5. Landscape & Visual Steeple Renewables Project

November 2025

**FIELDS FOR
FARMING**

P22-1144\_EN\_27\_A\_04

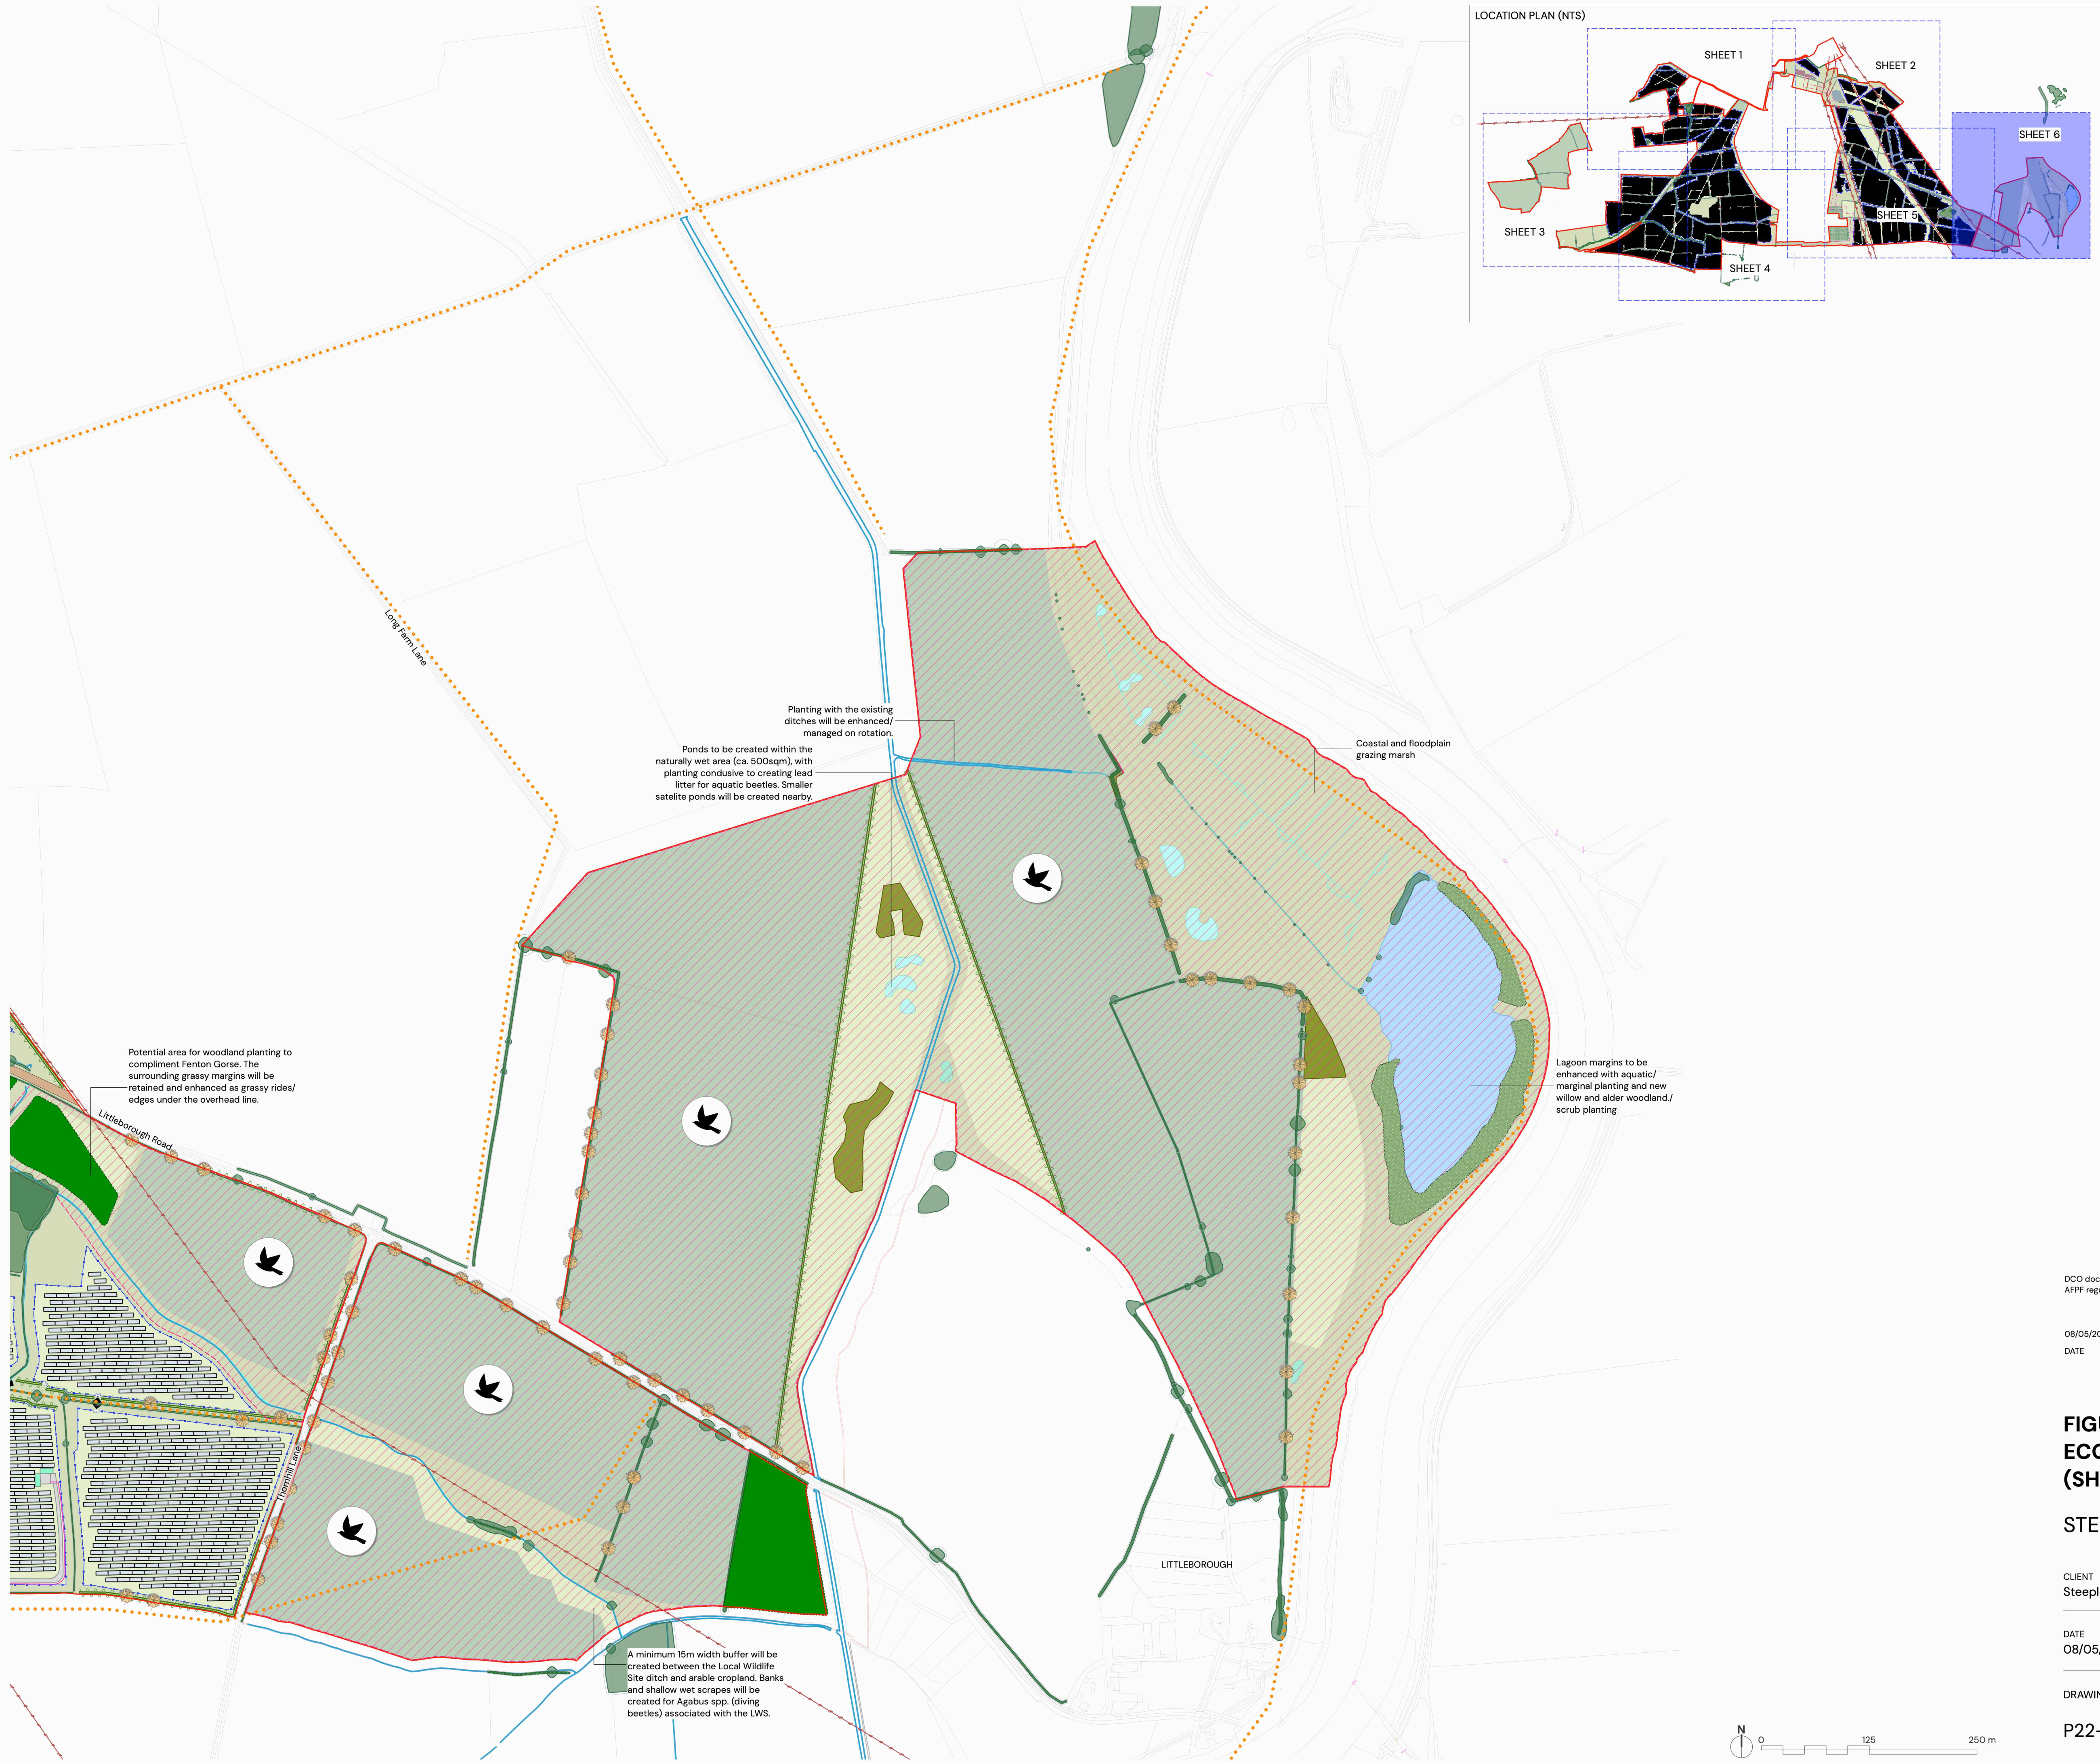
Numerous Public Rights of Way (PROW) and permissive paths intersect the Site and are shown on Figure 6.9 Outline Landscape Mitigation Strategy [EN010163/APP/6.4.6]. The maintenance of these has been considered in relation to their influence on habitat condition, for example greater hedgerow cutting frequencies may be needed adjacent to PROW, but management prescriptions for the PROW have not been specified, as they do not have their own ecological objectives.

It is difficult to determine from the above whether the hedgerows bordering the PROW will be managed or not or indeed in what manner which has an impact on visual assessment outcomes, and how their impact on NBG can be assessed if the management of them is not determined.

The applicant confirmed they intend to plant/allow existing hedgerows to grow either side of Trent Valley Way and other PROWs. These hedges will be allowed to grow to 3m high, and it is not clear how often these hedgerows will be maintained. The applicant claims this will still afford pleasant and open views. This is simply not true, the proposed 15m wide routes with 3m hedges will not feel "open and pleasant" in a rural landscape; they create a confined, engineered corridor that fundamentally changes the character of the Trent Valley Way and public right of way.

VIEWPOINT 1A

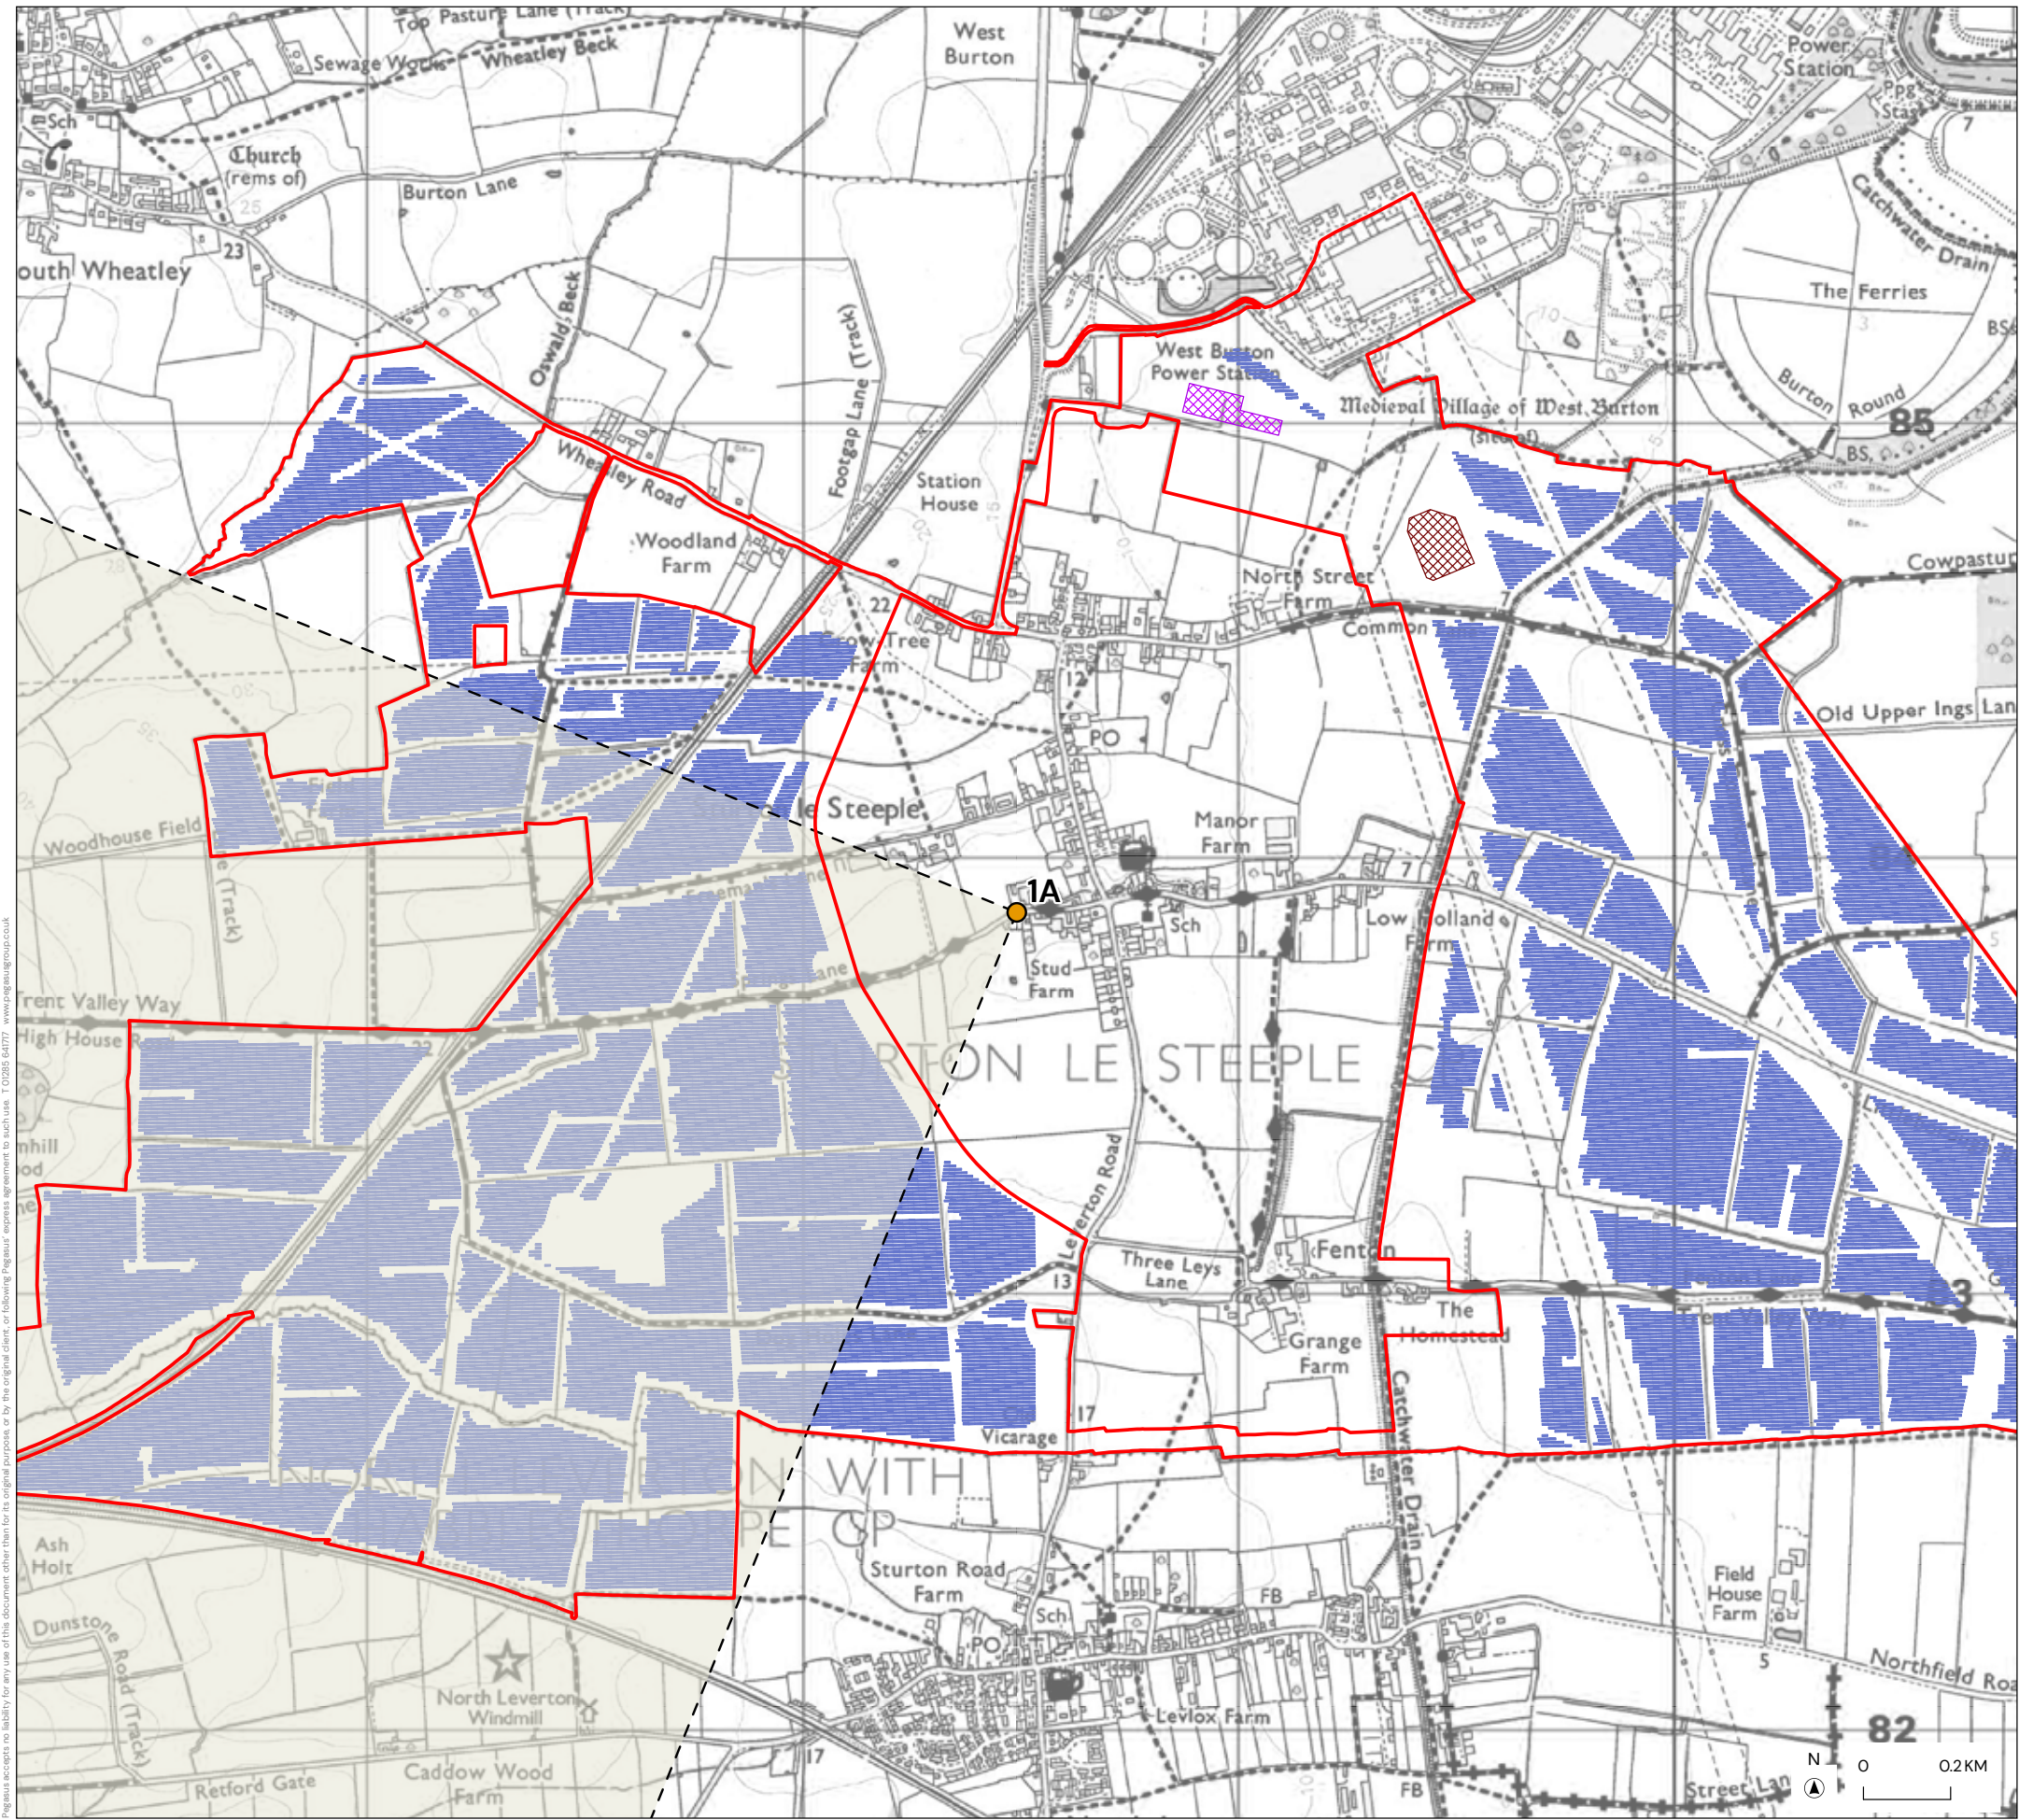
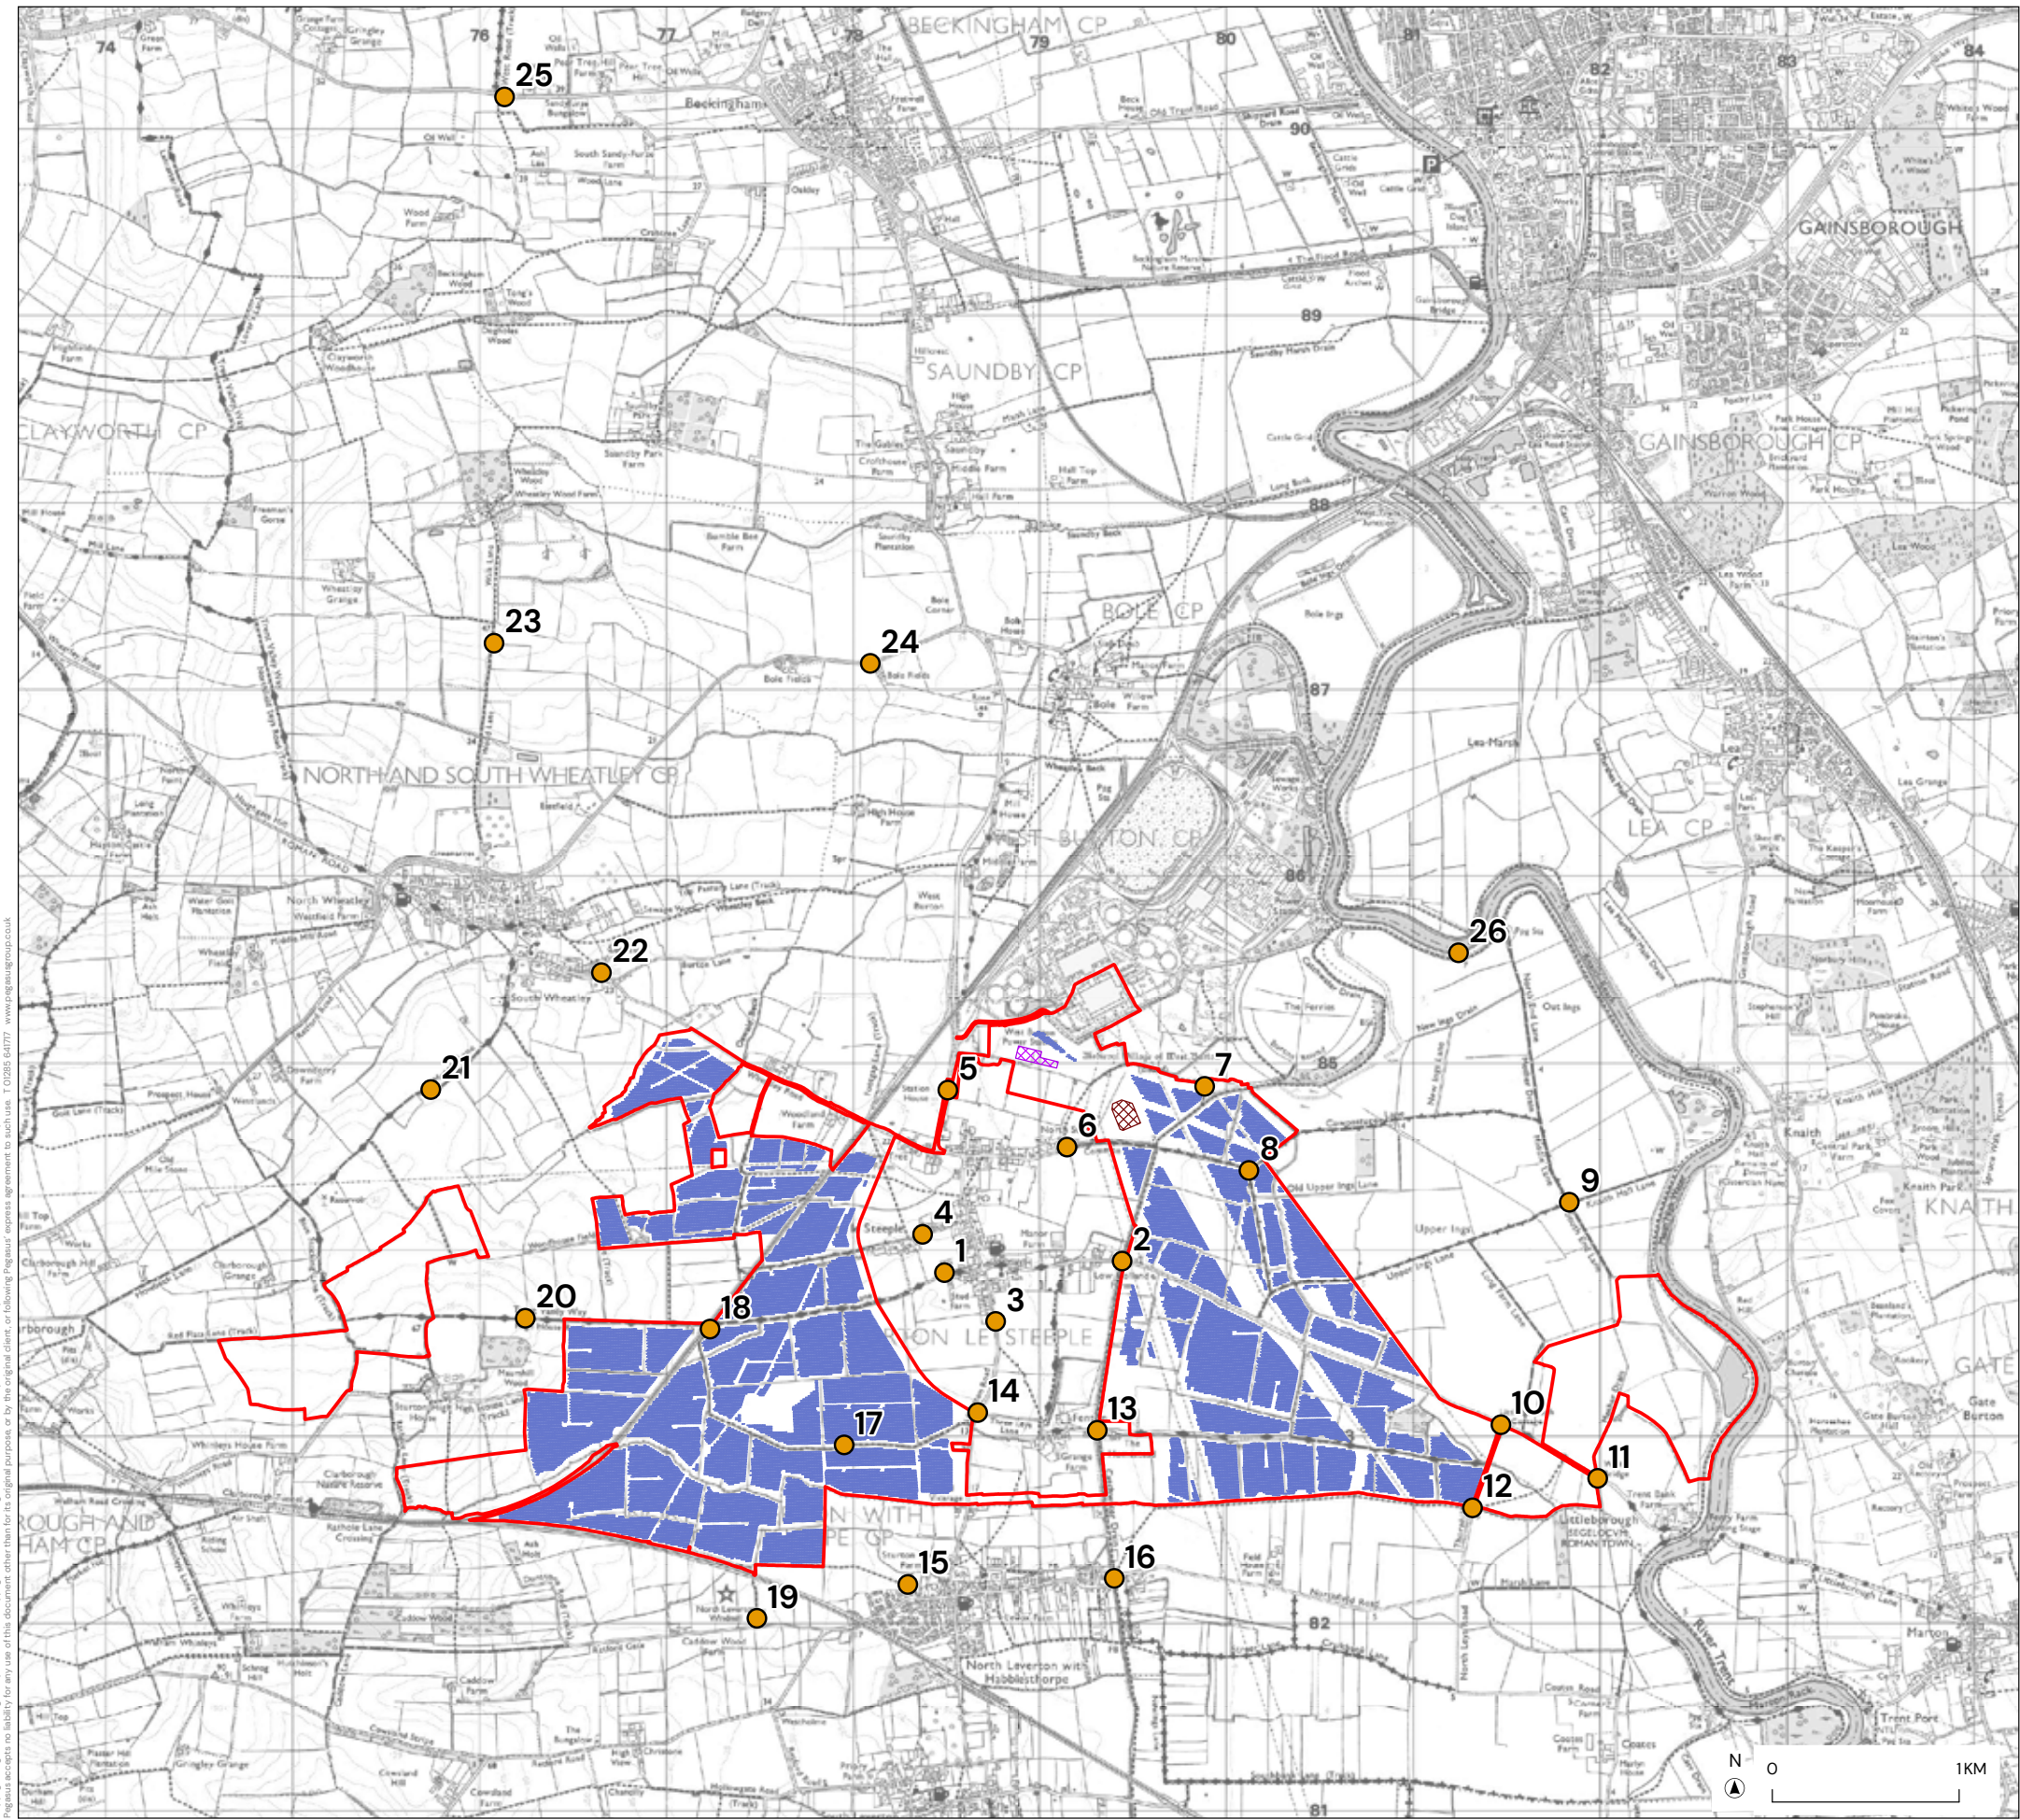
VP 1A & 1B represent Trent Valley Way – Solar is not proposed in these two fields (these fields are not in the red-line. The site is beyond the farm buildings depicted).
